**From:** Joyce Christie  
**Sent:** 14 October 2019 13:36  
**To:** James Kirkham  
**Subject:** 19/01148/F and 19/01149/LB

**Joyce Christie**  
**Conservation Officer**  
**Planning Policy, Conservation and Design**  
Place and Growth Directorate  
Cherwell District Council

Drawing No
2016-34/06C

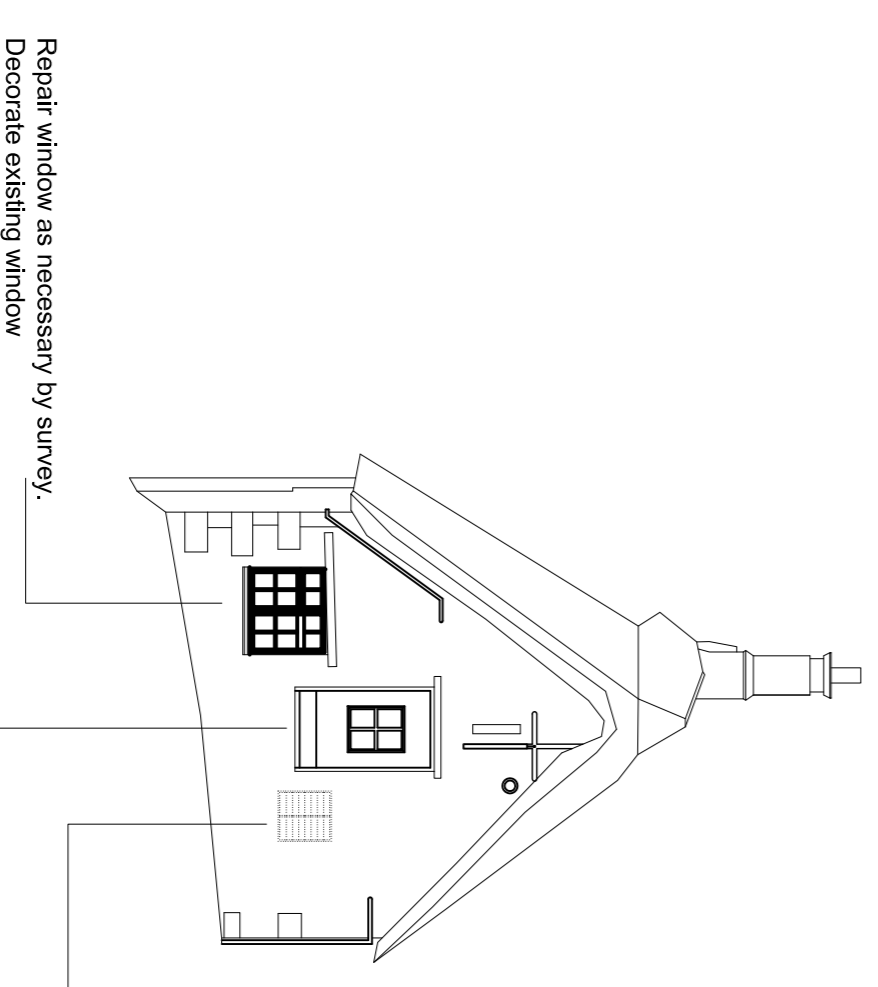
**Louvred to roof of kitchen** – to detail – they are too close to the ridge as shown. The side elevation and the front elevation appear to be different in terms of size?

Drawing No
2016-34/05G

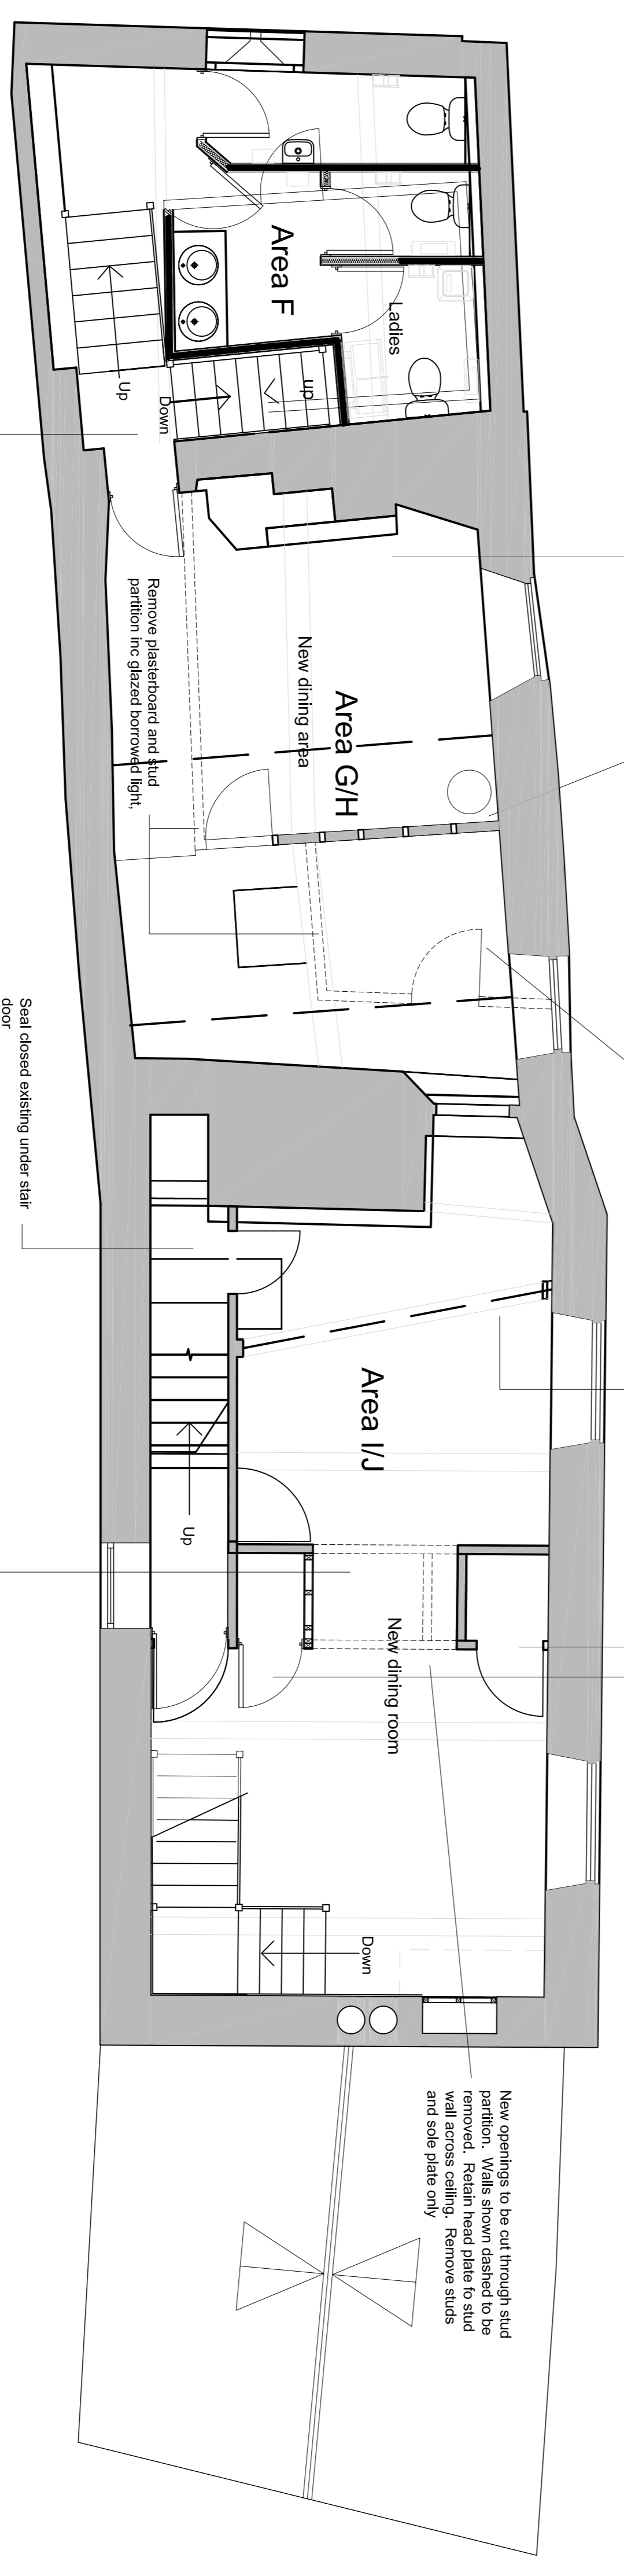
Area G/H, it is not clear on the dr 05G that the corner post/jamb to the 19<sup>th</sup> century door or is being retained or removed?
